Our Ref: AW/281/18/T
Your Ref:

Town & Country Planning Act 1990 (as amended)
Town & Country Planning (Tree Preservation) (England) Regulations 2012
Application for Works to Tree(s) on trees subject to a Tree Preservation Order (TPO)

Development Surgery to 1No. Lombardy Poplar and 1No. Horse Chestnut tree.

Location 25 Rucrofts Close Aldwick Fields

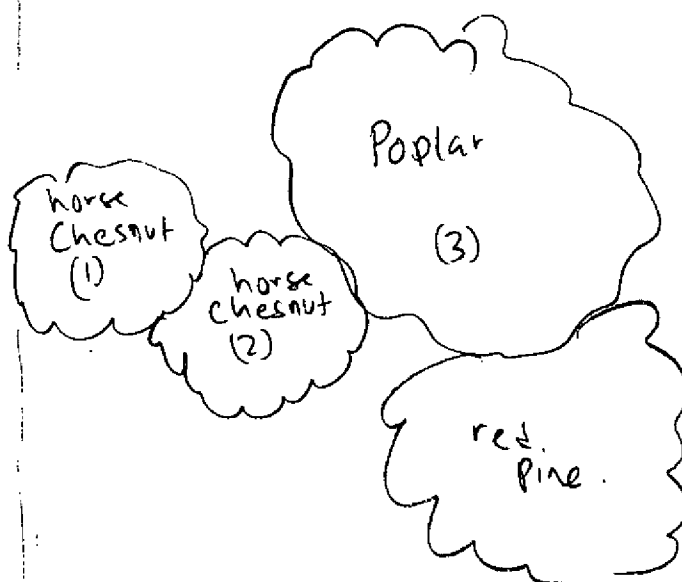
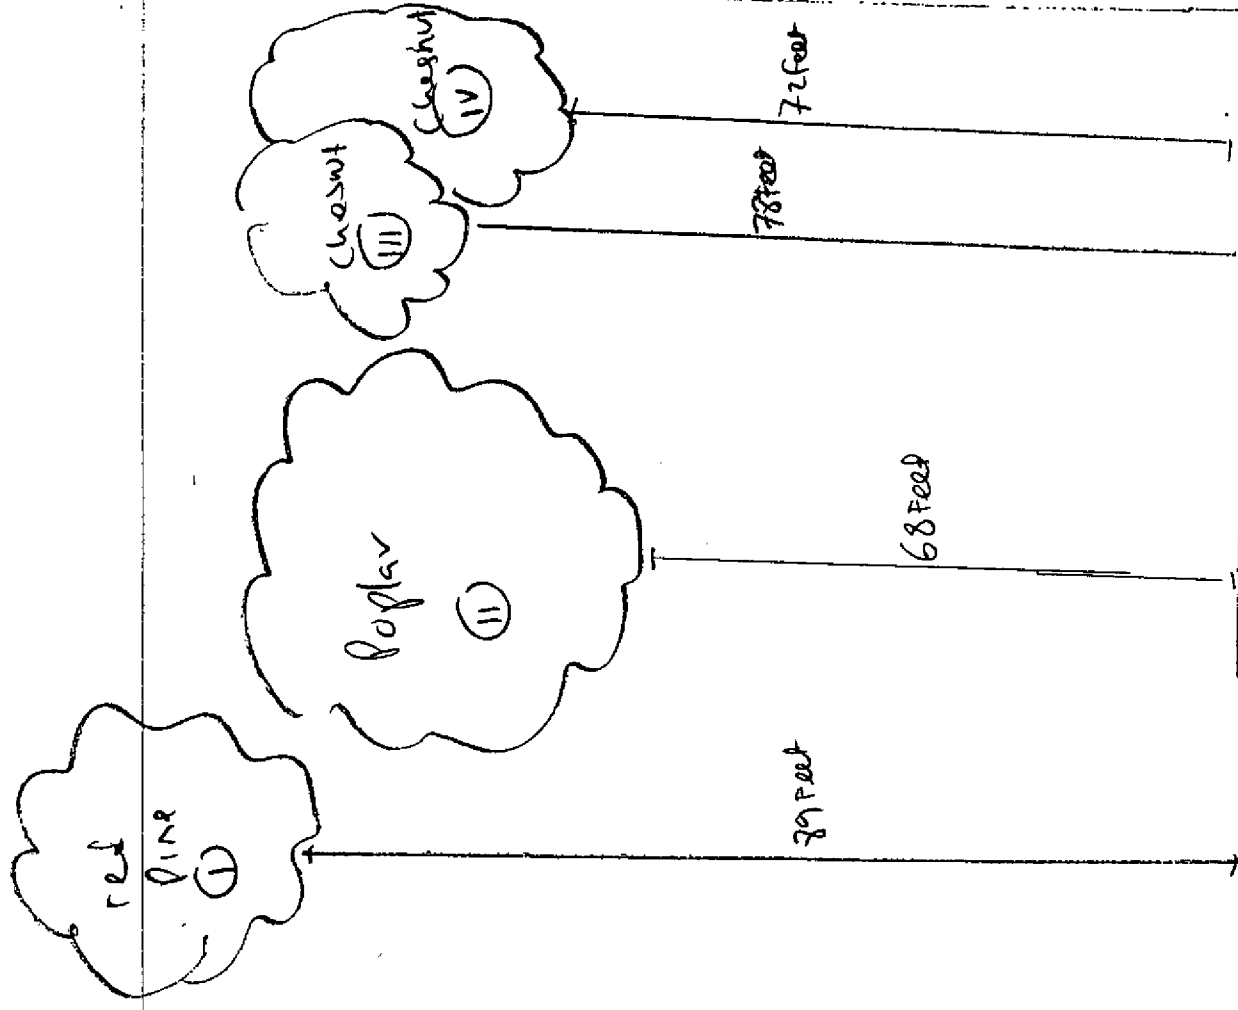
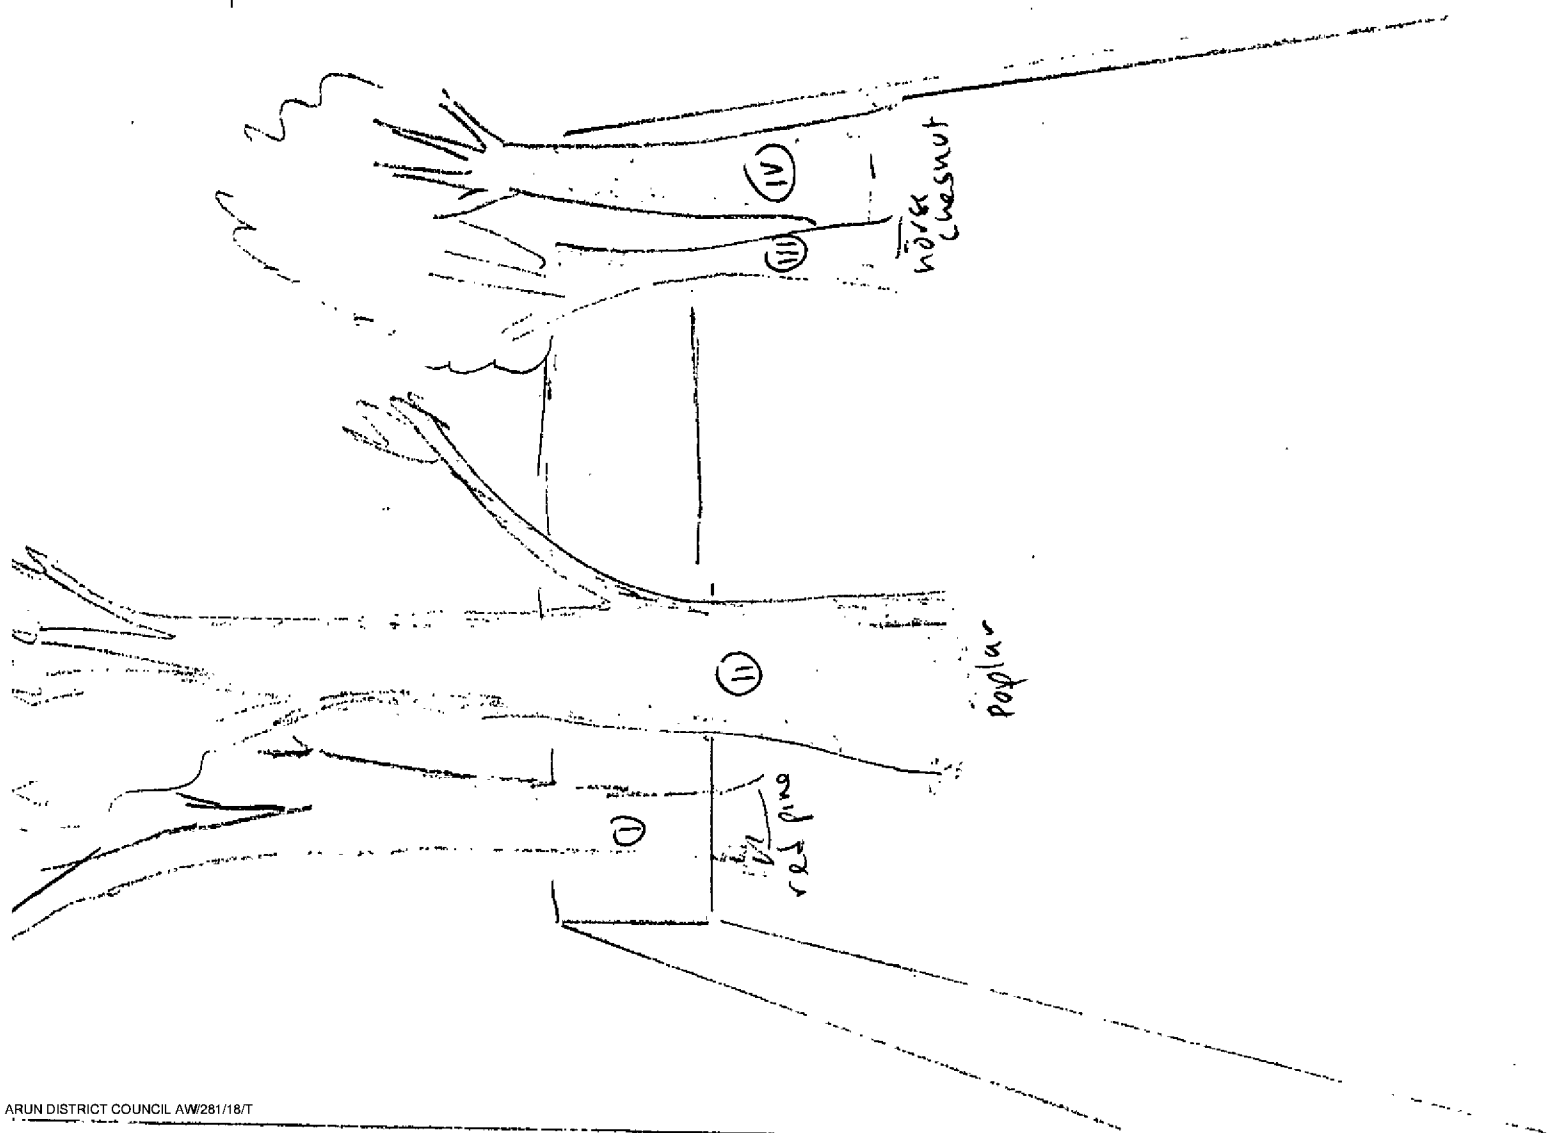
Please highlight which Horse Chesnut tree required thinning.

1No. Lombardy Poplar please advise the height reduction in metres.

1No. Horse Chesnut tree please advise the percentage of crown thin.
